Stage 1 Road Safety Audit

Cloghercor Wind Farm, Co Donegal

On behalf of Cloghercor Wind Farm Ltd.

February 2023

ROAD CONSTRUCTION DETAILS

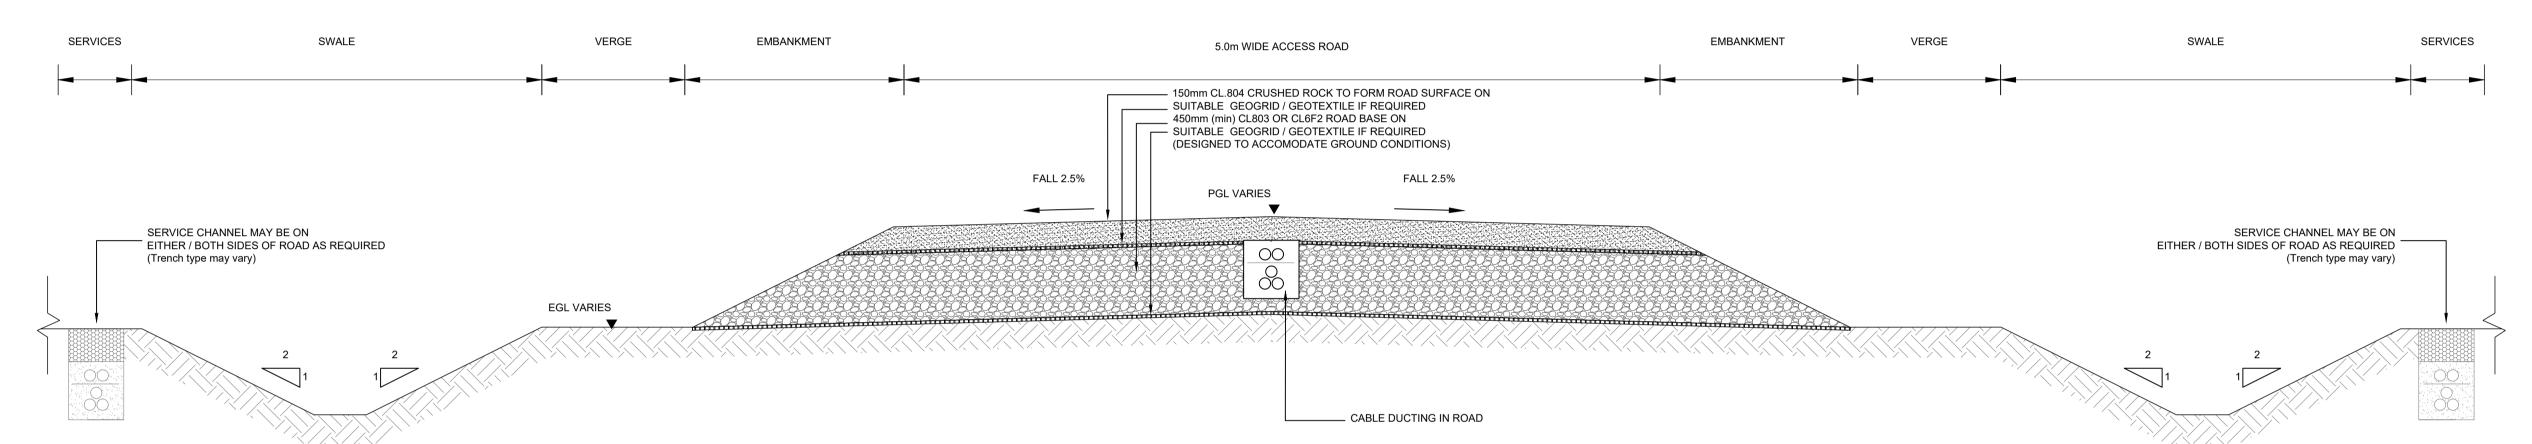
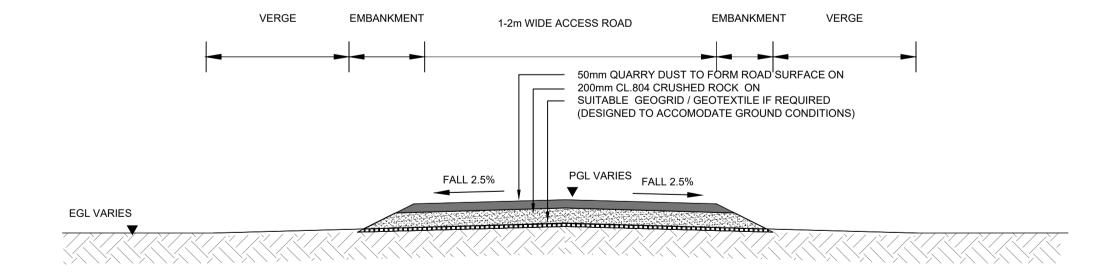
Problem: No construction details are provided for the proposed access roads. There is risk that the roads are intended to remain with an unbound surface.

Recommendation: Ensure the proposed roads are finished with a suitable bound surface.
